WEST SUSSEX COUNTY COUNCIL CONSULTATION

TO:	Arun District Council FAO: Amber Willard
FROM:	WSCC – Highway Authority
DATE:	3 February 2026
LOCATION:	The Croft Surgery Barnham Road Eastergate PO20 3RP
SUBJECT:	BN/130/25/PL Change of use of the existing building and associated facilities from a doctor surgery (Use Class E) to a place of worship (Use Class F) and all associated works and infrastructure. This application is in CIL Zone 2 (Zero Rated) as other development.
DATE OF SITE VISIT:	n/a (desktop study undertaken)
RECOMMENDATION:	More Information Required

Proposed Ground Floor Plan

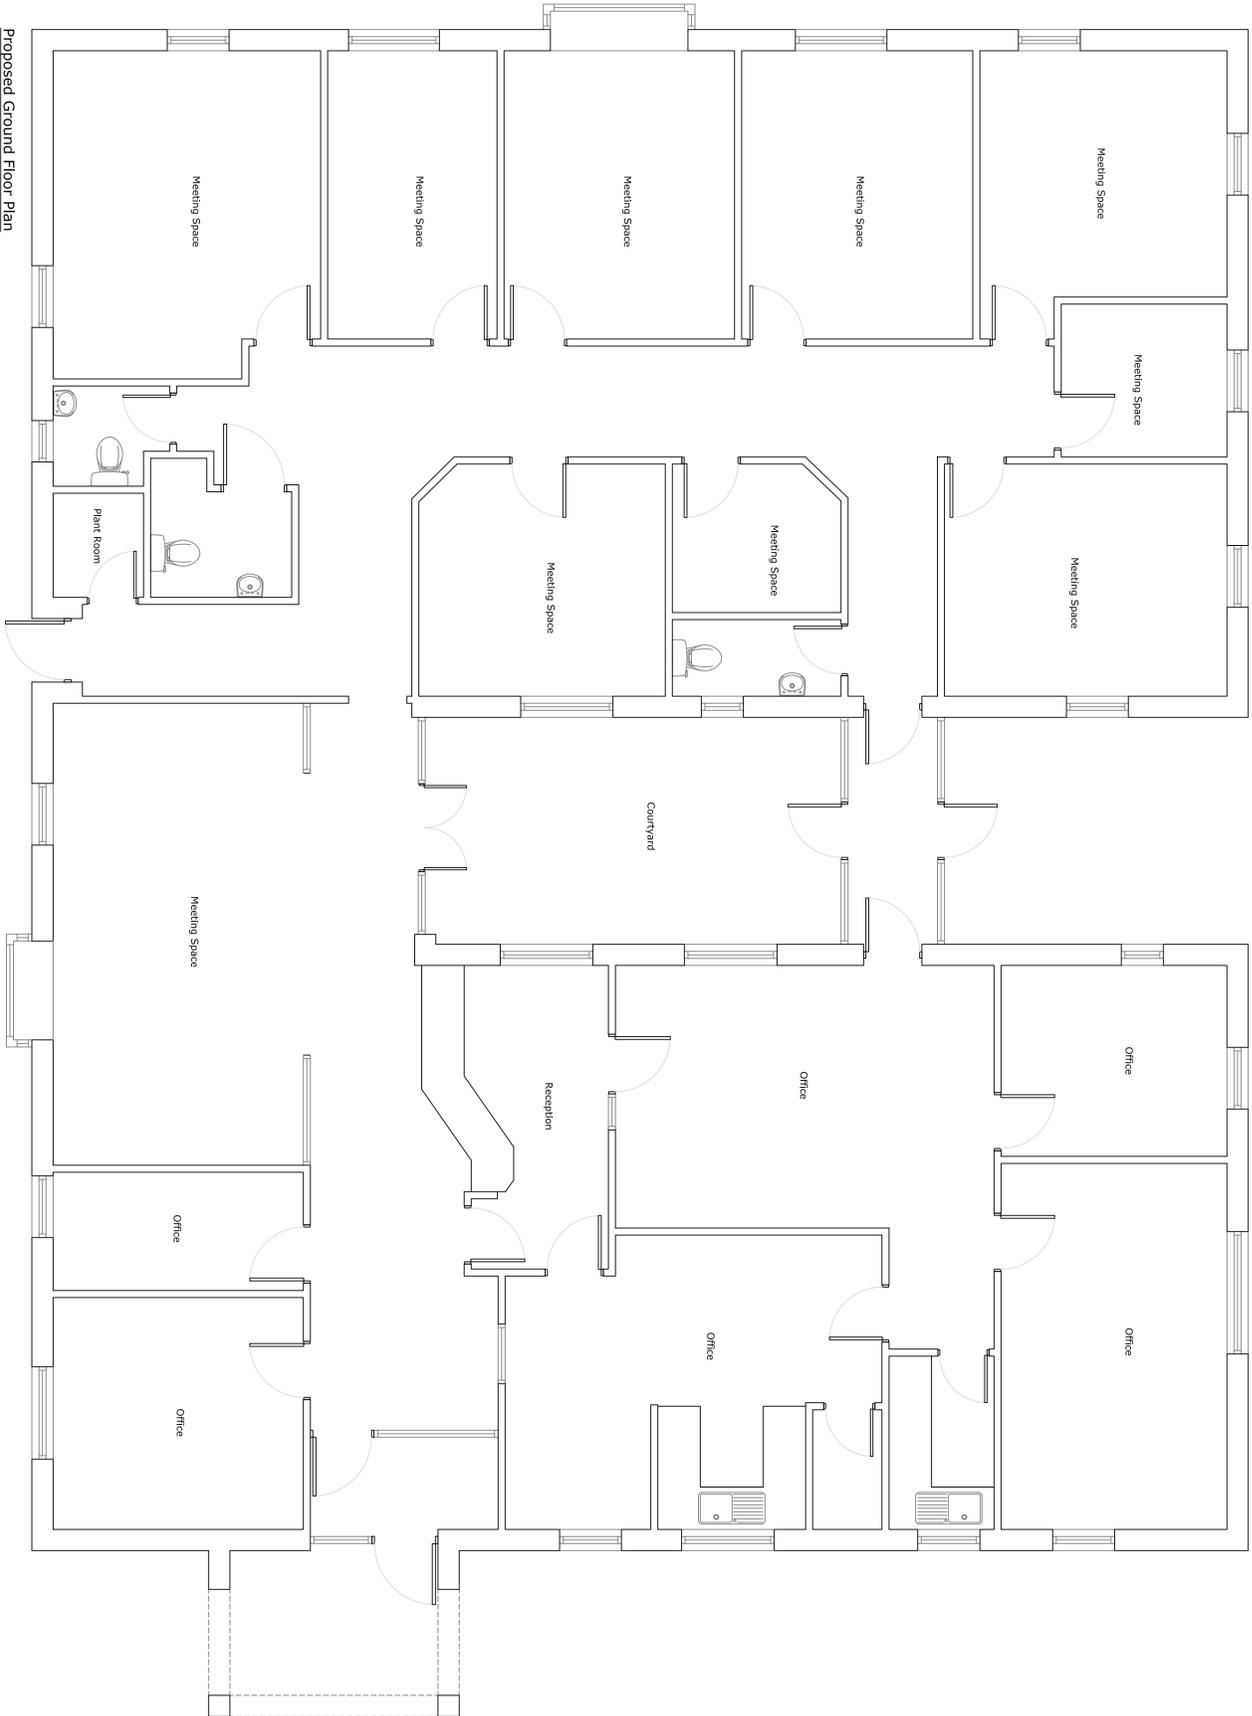
- 1.** The floor plans show a large number of rooms within the building, previously used as either consulting rooms or small meeting rooms when the building was in use as a doctor's surgery. As such, there does not appear to be a main worship area which is traditionally associated with church buildings. Applicants to explain how the building will be used for their purposes, including numbers of parishioners expected to be on site at any one time.

- 2.** As set-out in point 1 above, the building is divided into lots of small rooms. As Use Class F is being applied for, these rooms could be used for other uses without the need for further planning permissions – e.g. clubs, classes etc - and at different (or same) times from the activities already mentioned in the planning statement. This could lead to additional activity on the site, including traffic generation at varying times and on the same or different days as currently stated in the supporting information, unless specific planning controls form part of any planning permission. As such, the applicants should confirm whether they are seeking F1 or F2 Use Class or simply F (where swapping between F1 and F2 doesn't require planning permission). Also, will some form of control be placed on any planning consent, if granted, to prevent this?

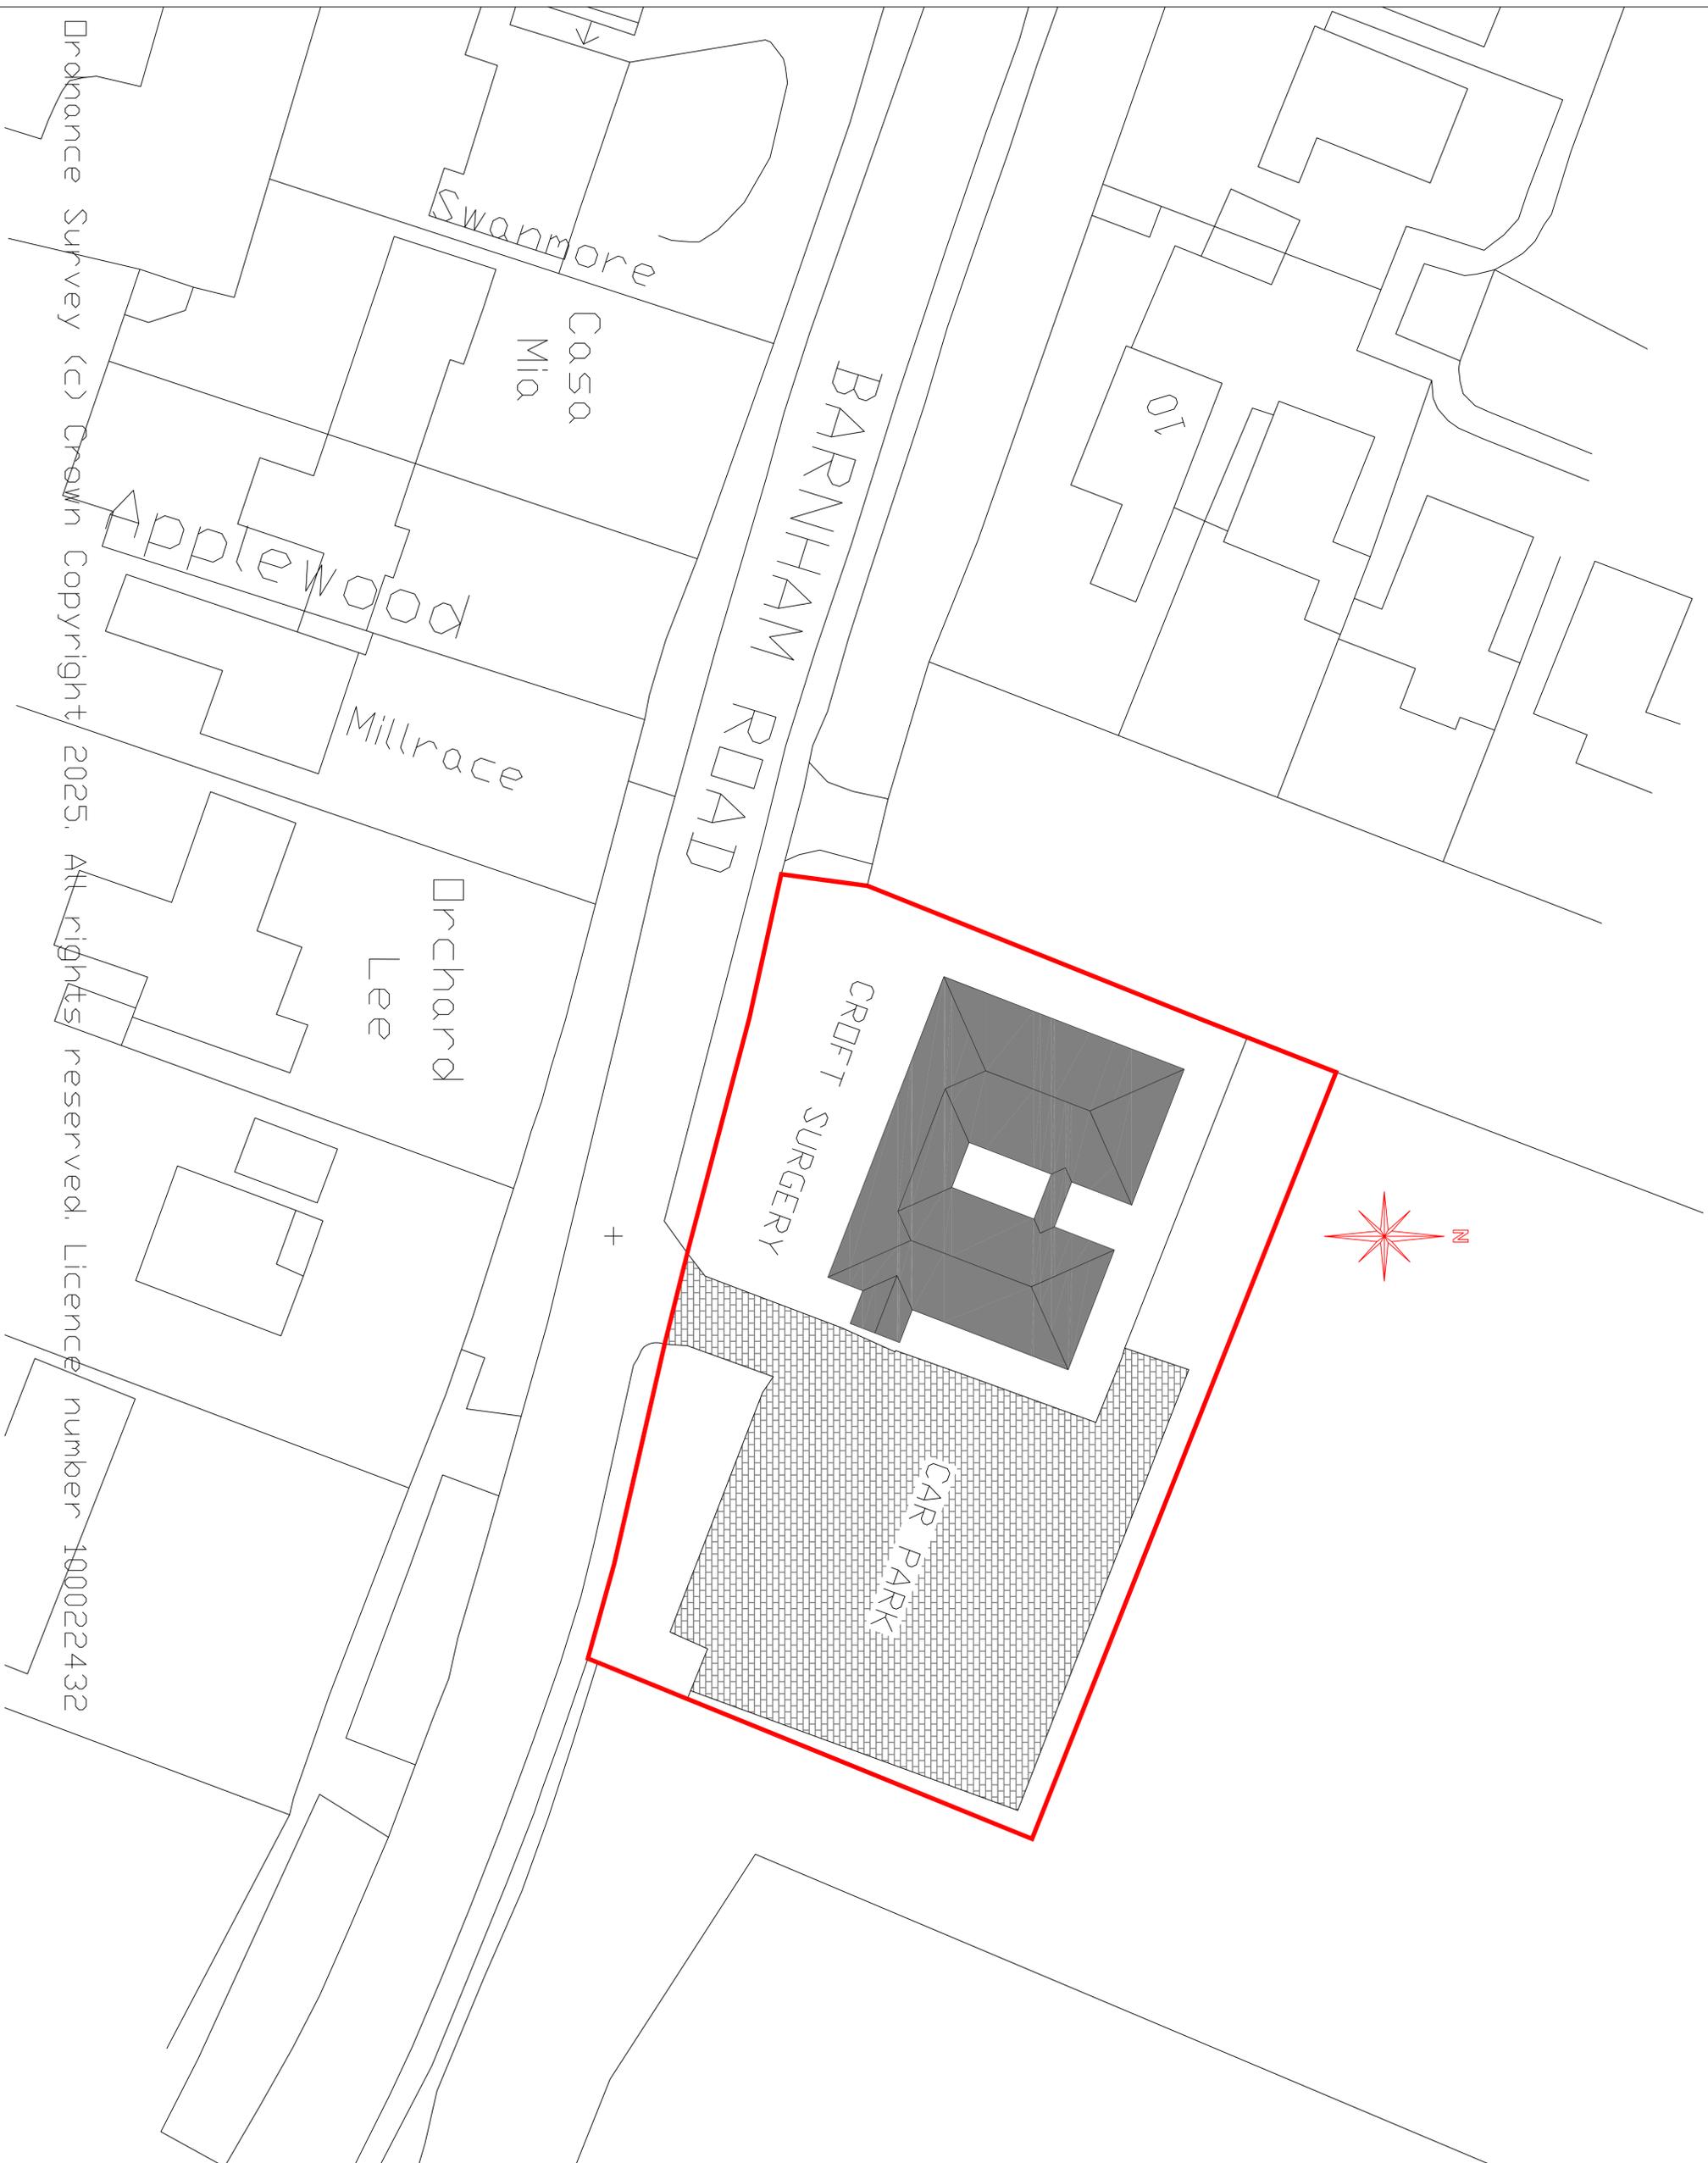
- 3.** Consideration should be given to installation of tactile paving either side of the existing access and creation of a bespoke footway/path into the site running alongside the access (otherwise users will have to share the vehicular access).

4. It is recommended that secure and covered cycle parking and EV parking should be provided on-site.
